Application for a Non-Material Amendment Following a Grant of Planning Permission

Erection of 6 detached dwellings and associated internal road, landscaping and external works.

DC/2022/01453

To change the art stone banding to the front elevation to a brick dentil course.

| Drawing Title: | GA ELEVATIONS - PLOT 1, 3 & 5 |

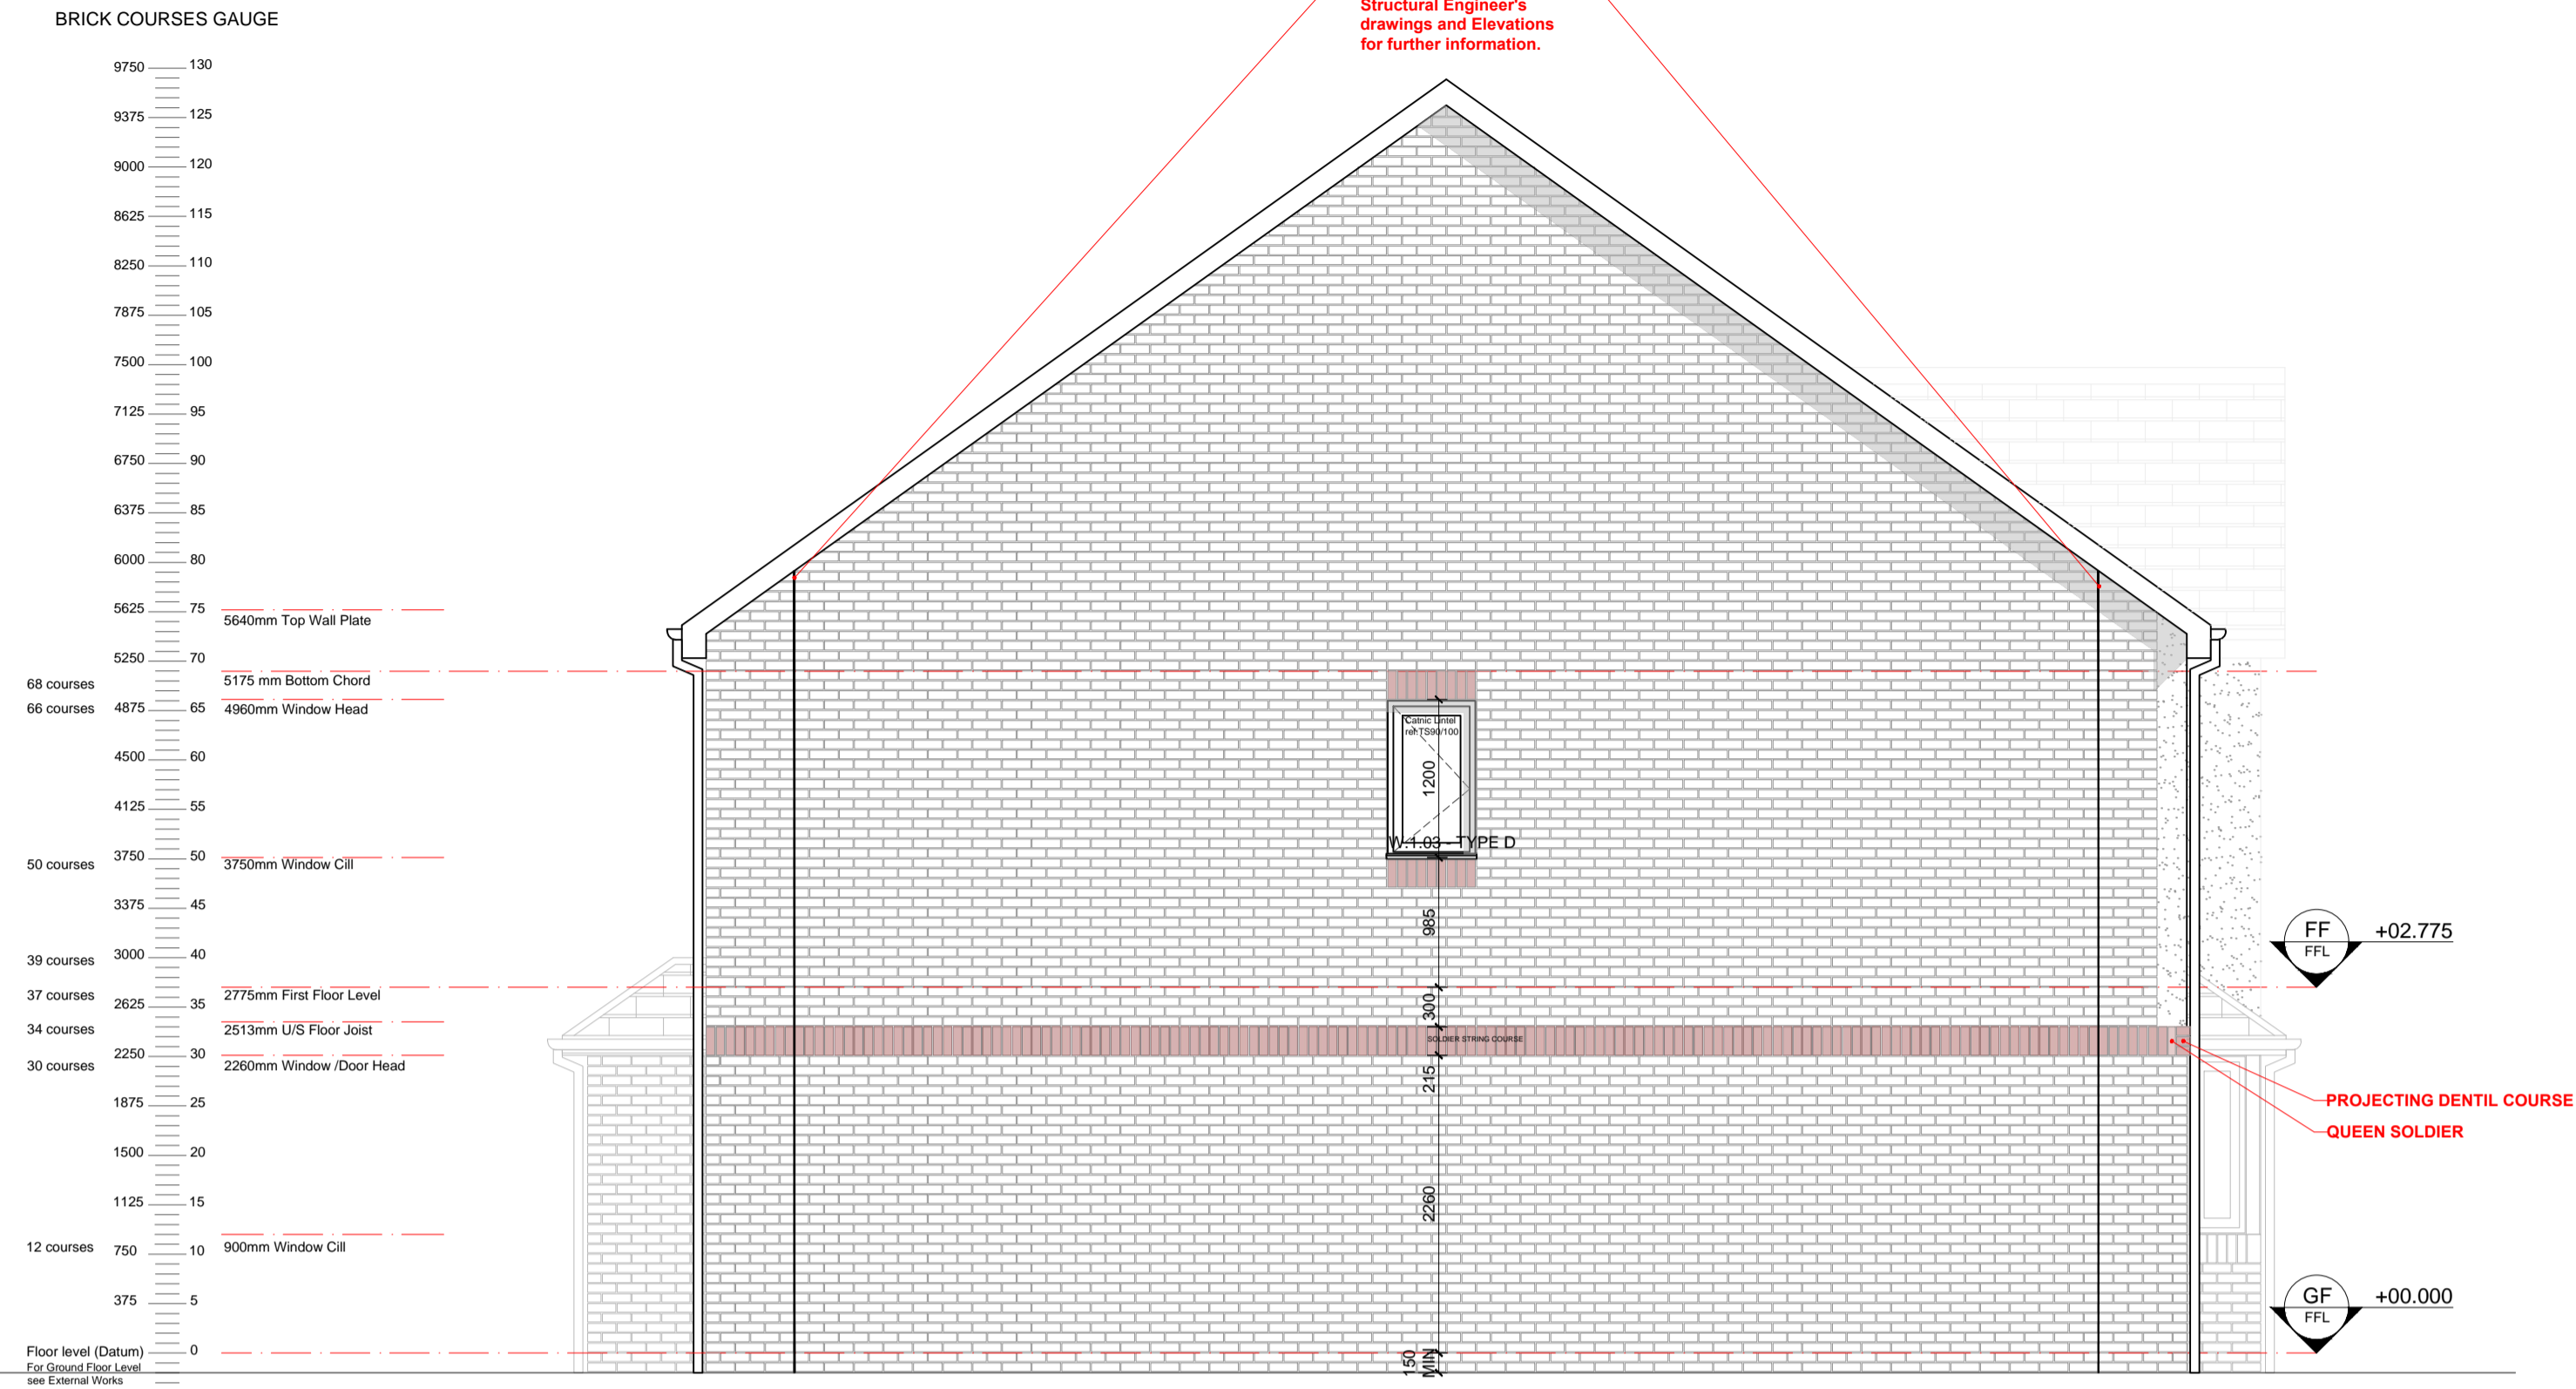
A brick dentil course is more contextually informed/appropriate than the originally proposed art stone banding.
